Please could you upload the e-mail below to the application folder BN/57/19/RES as a consultation response from Barnham & Eastergate Parish Council?

DATE	DRAWING No.
17-03-20	WM/627/12

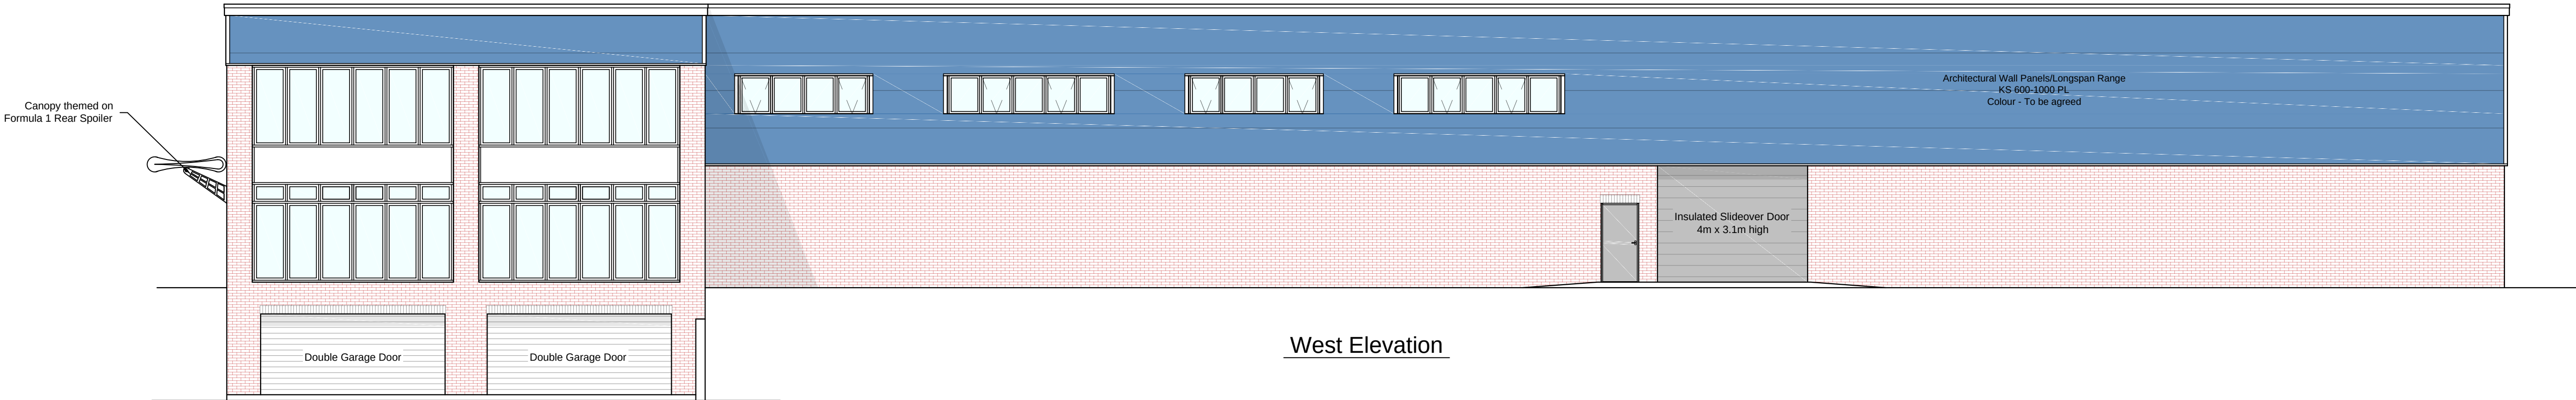
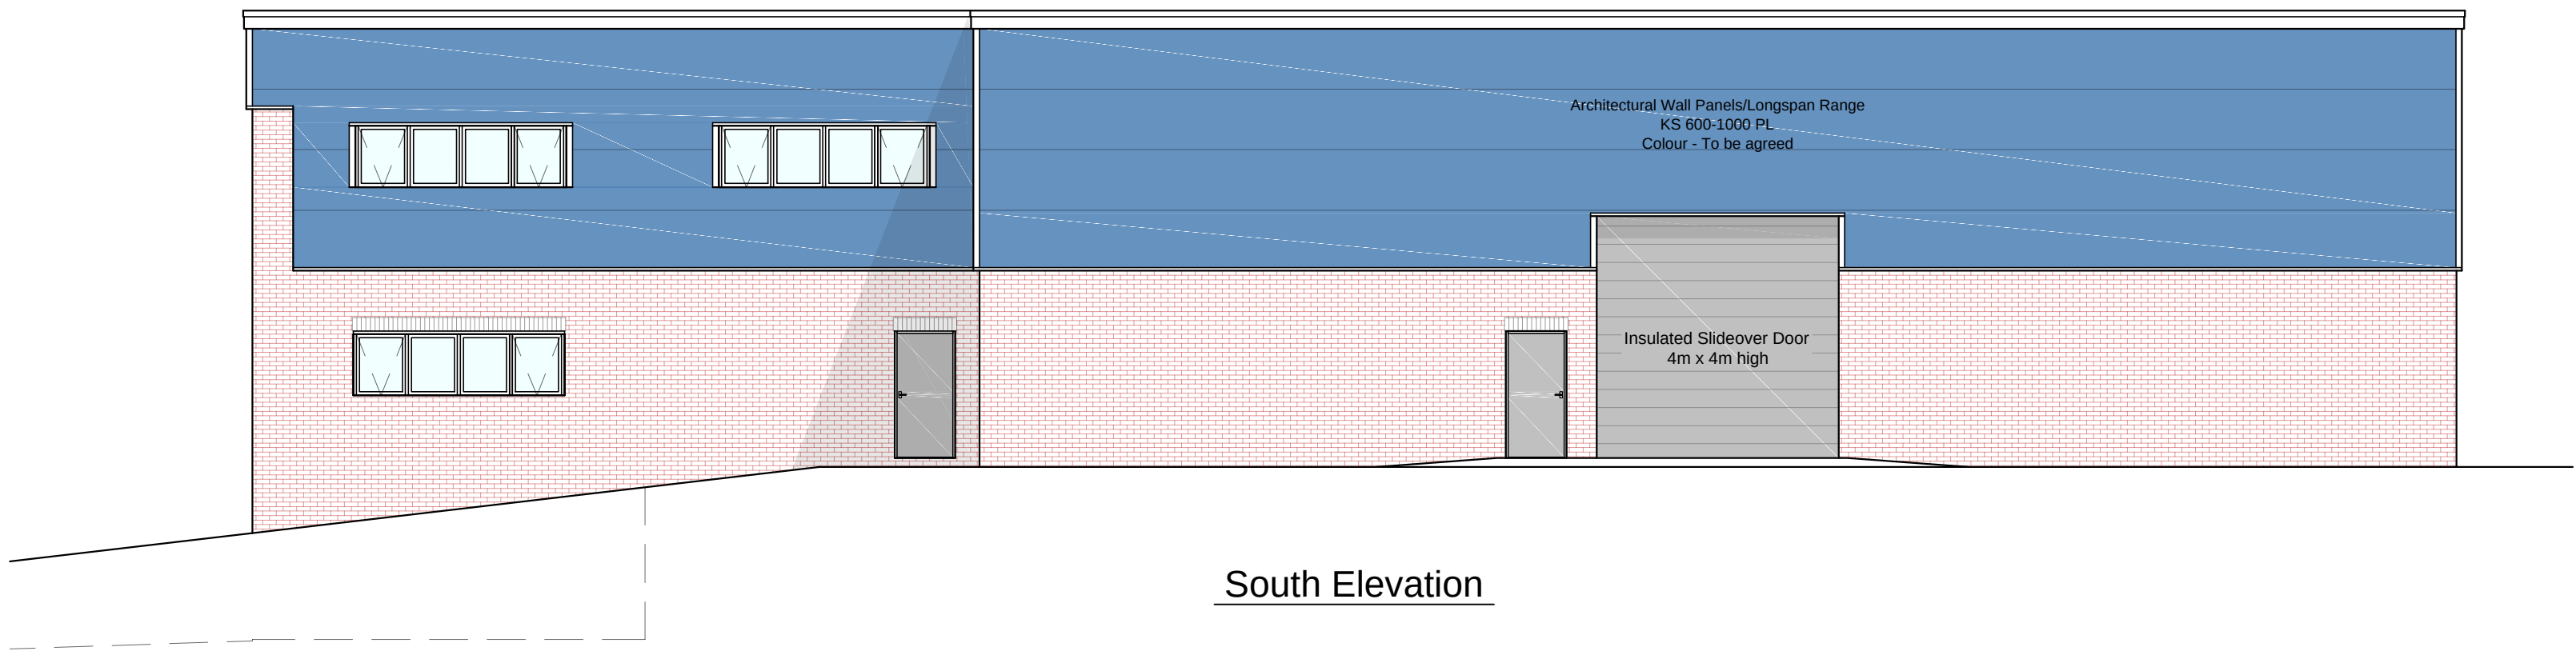
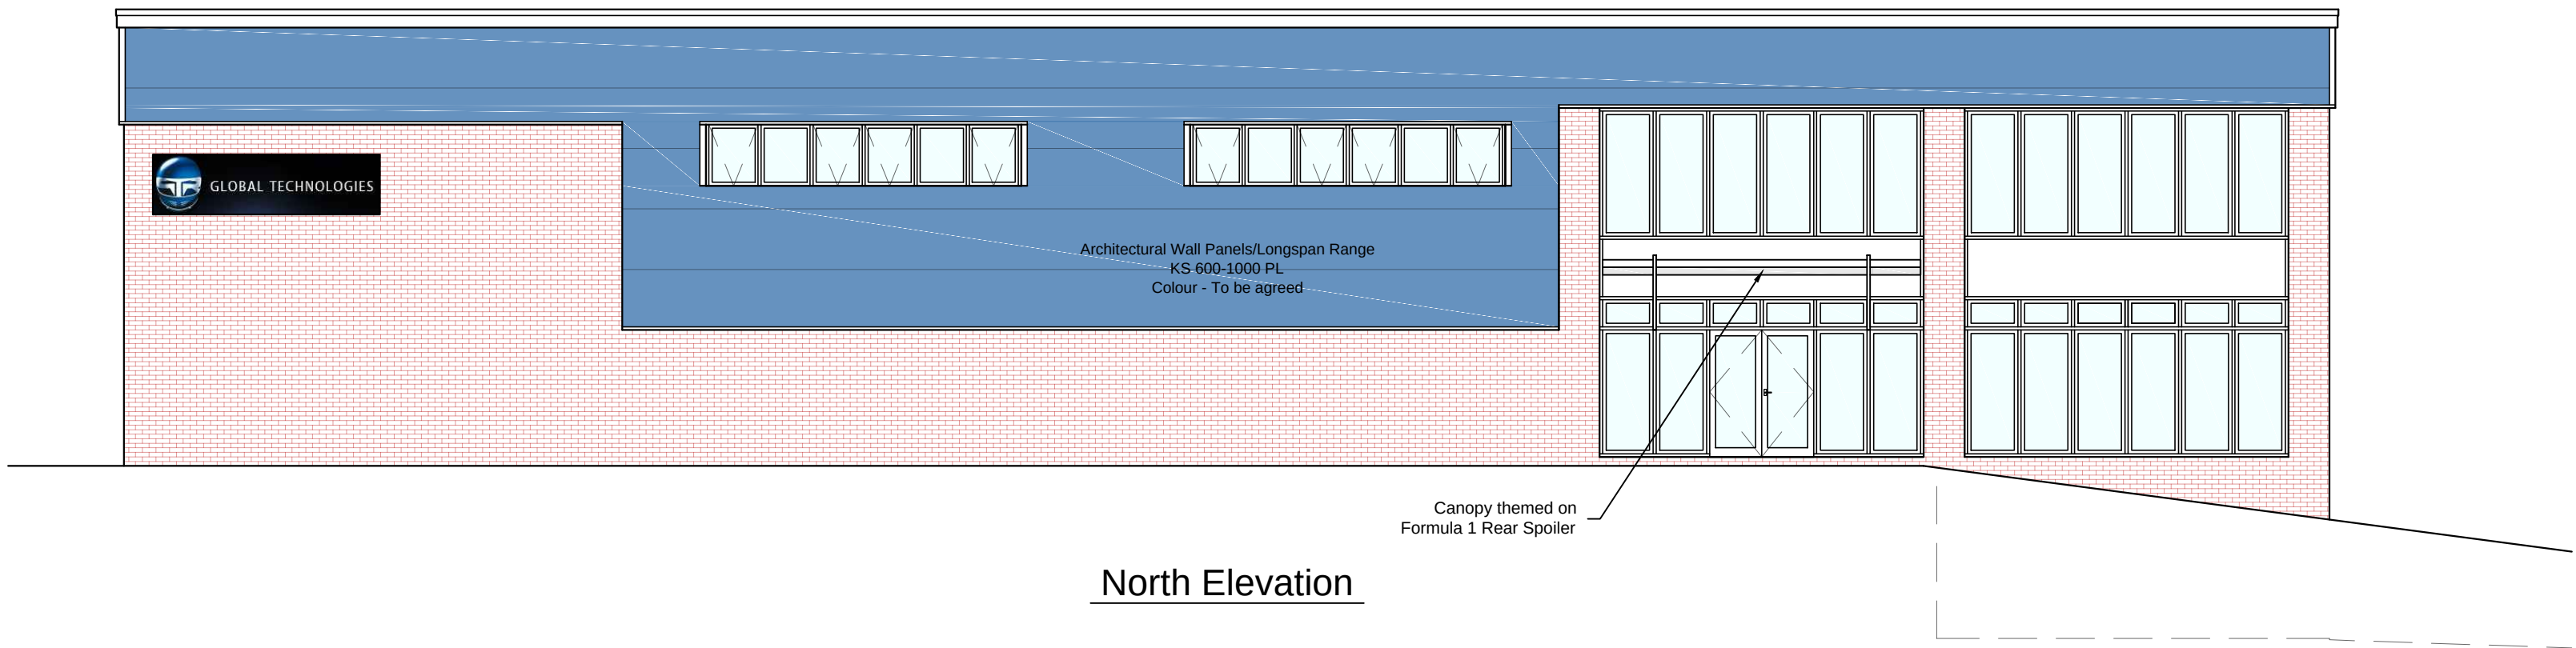
1. The aesthetics and design of the building which they feel is too high and not at all an attractive design even for an industrial unit and hope that something can be done to improve this aspect of the application.
2. The Committee need to receive categoric assurances that the use of chemicals within the factory setting will not be able to find its way into the local water supply.
